OUT19/9623

Heather Nelson
Senior Planner
Planning and Assessment Group
NSW Department of Planning, Industry and Environment

**Moorebank Precinct East Concept Plan (MP 10_0193 MOD 3) and
Moorebank Precinct East Stage 2 (SSD 7628 MOD2)
EIS Exhibition**

**OSD BASIN STORAGE DETAILS**

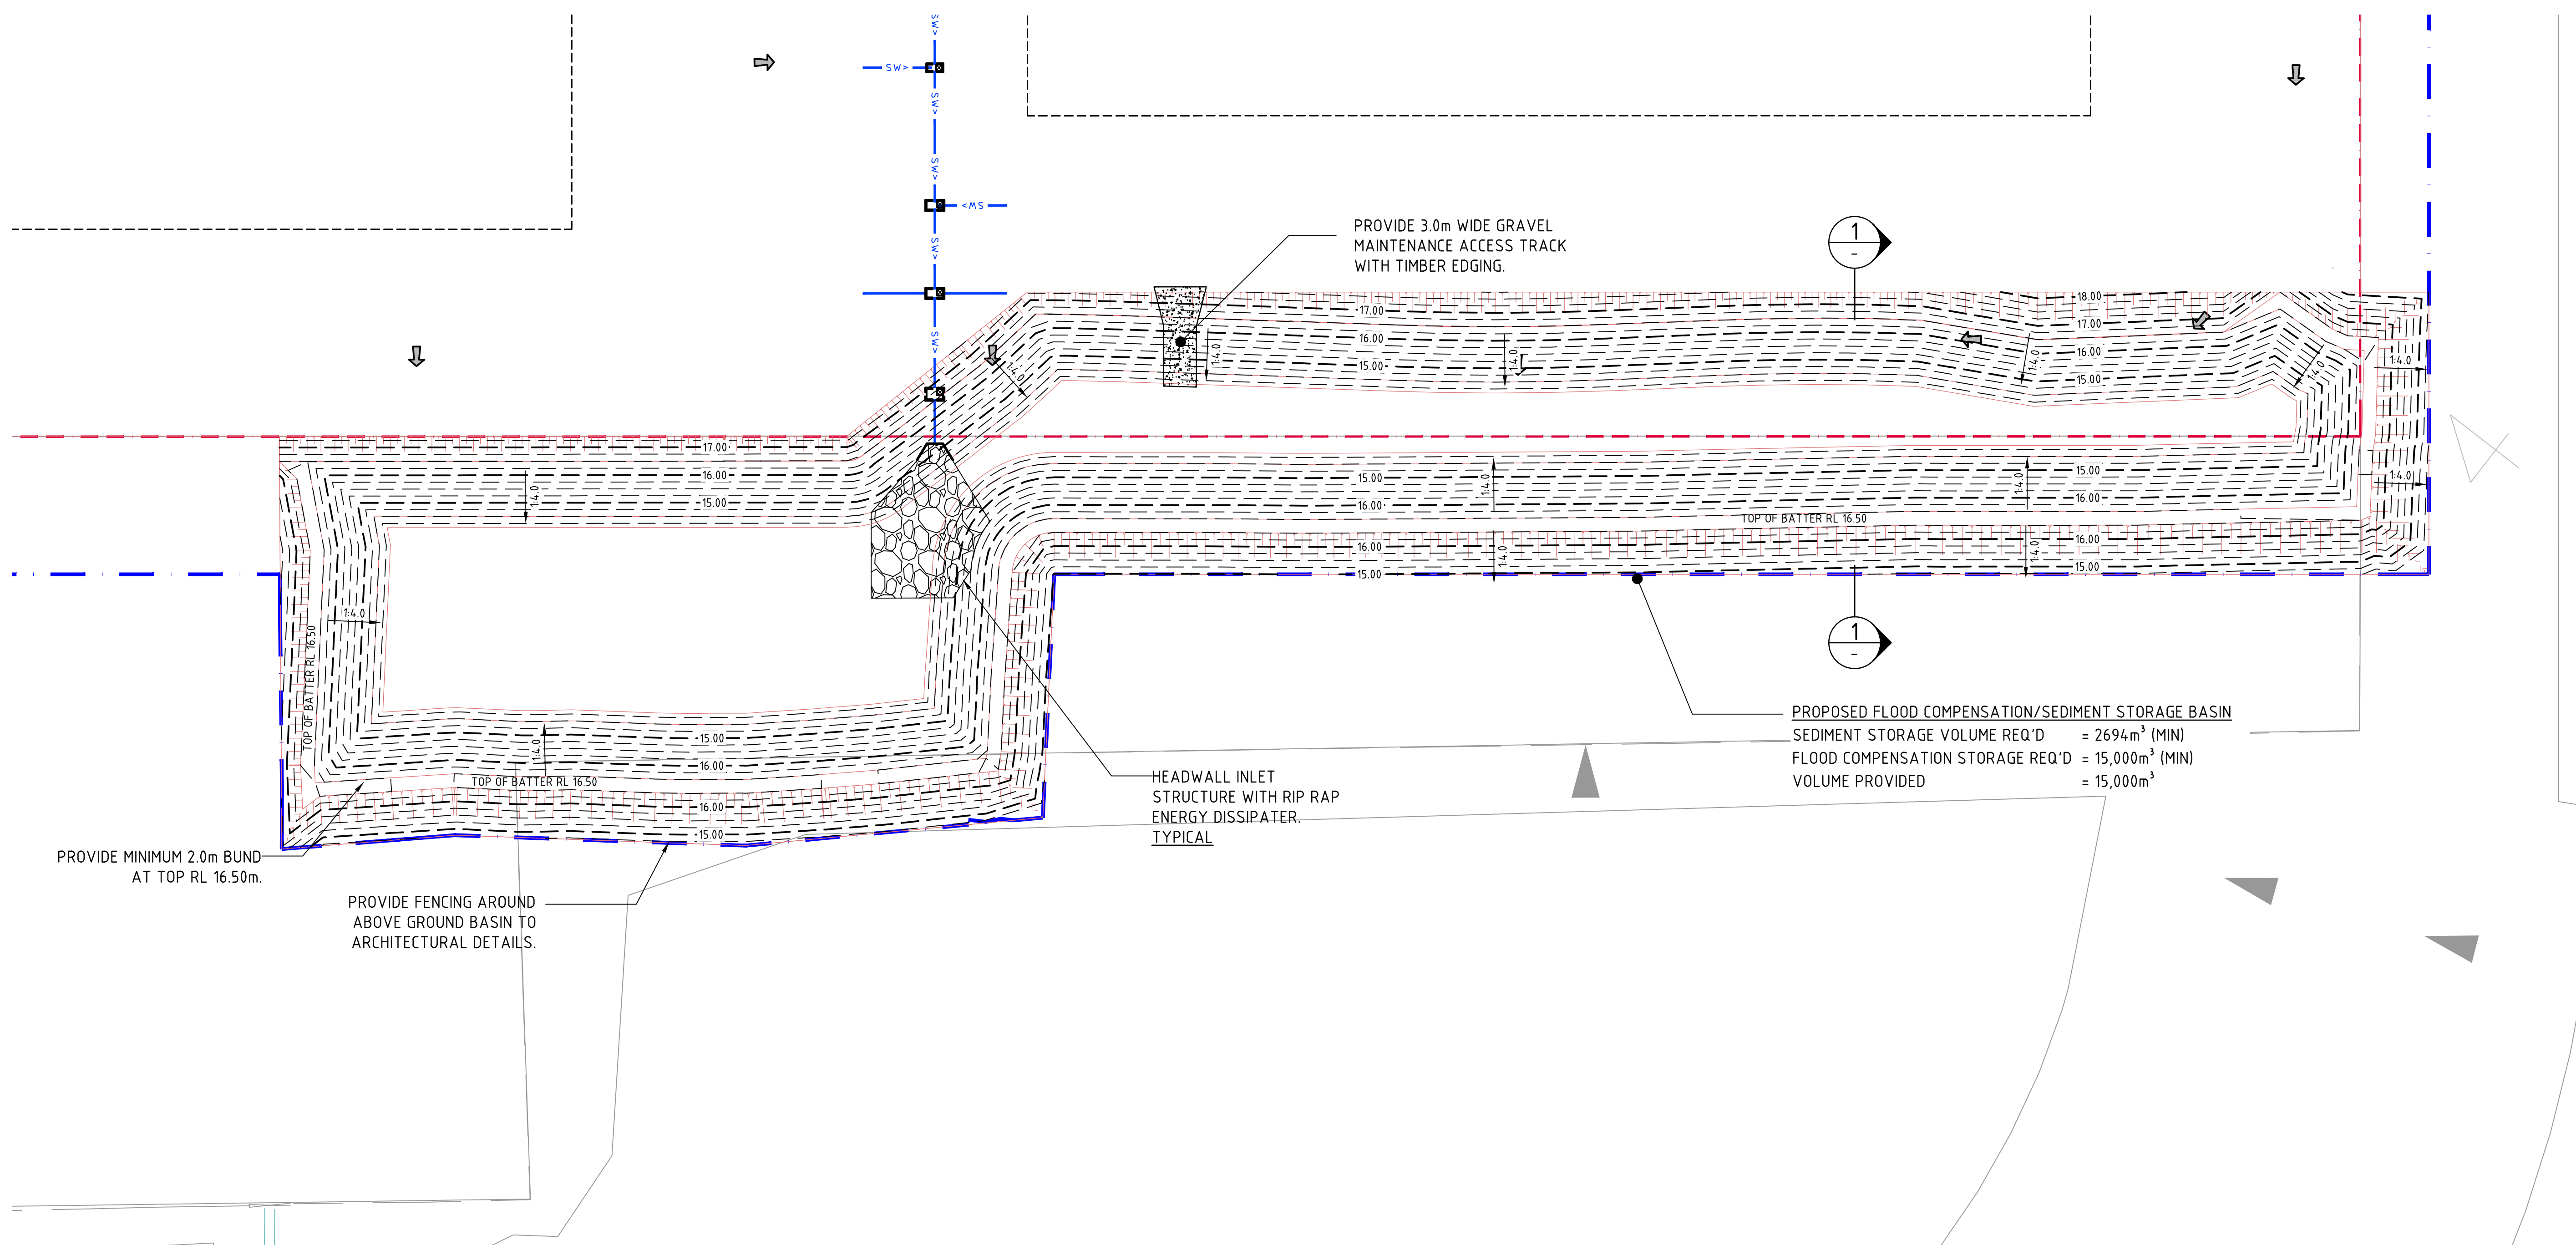
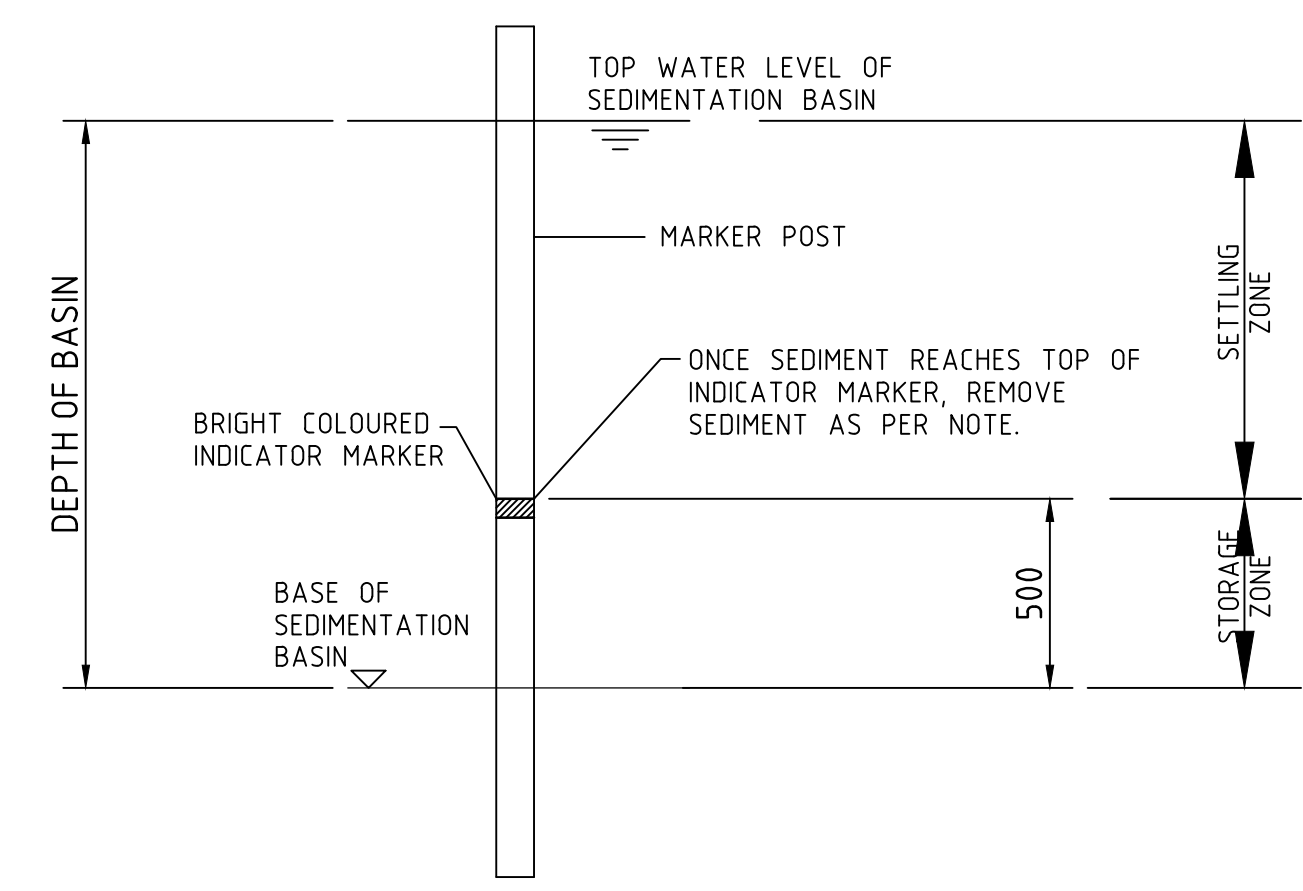
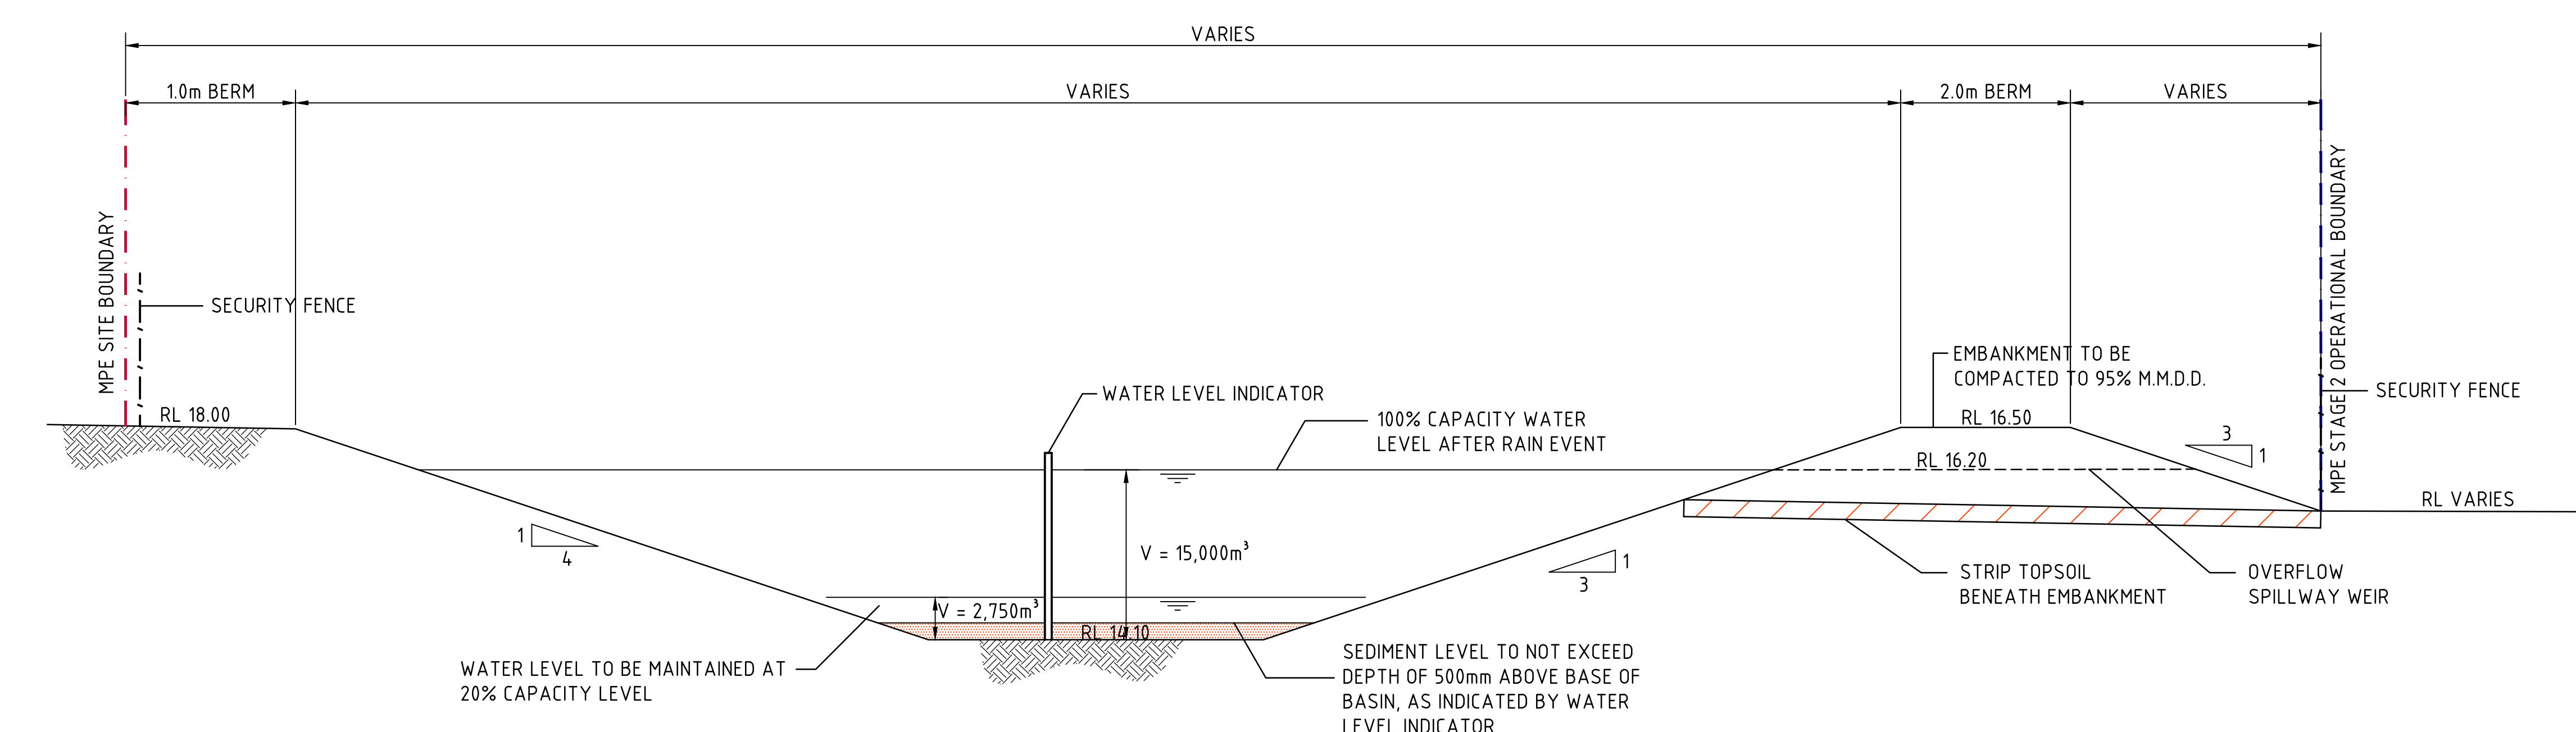
As a mitigation measure, the stormwater retention ponds may require an impermeable liner where they intercept the water table. This would be required where recharge of poor quality water from the ponds could compromise the aquifers highest beneficial use. DPIE Water will need to consider this further at the detailed design stage.
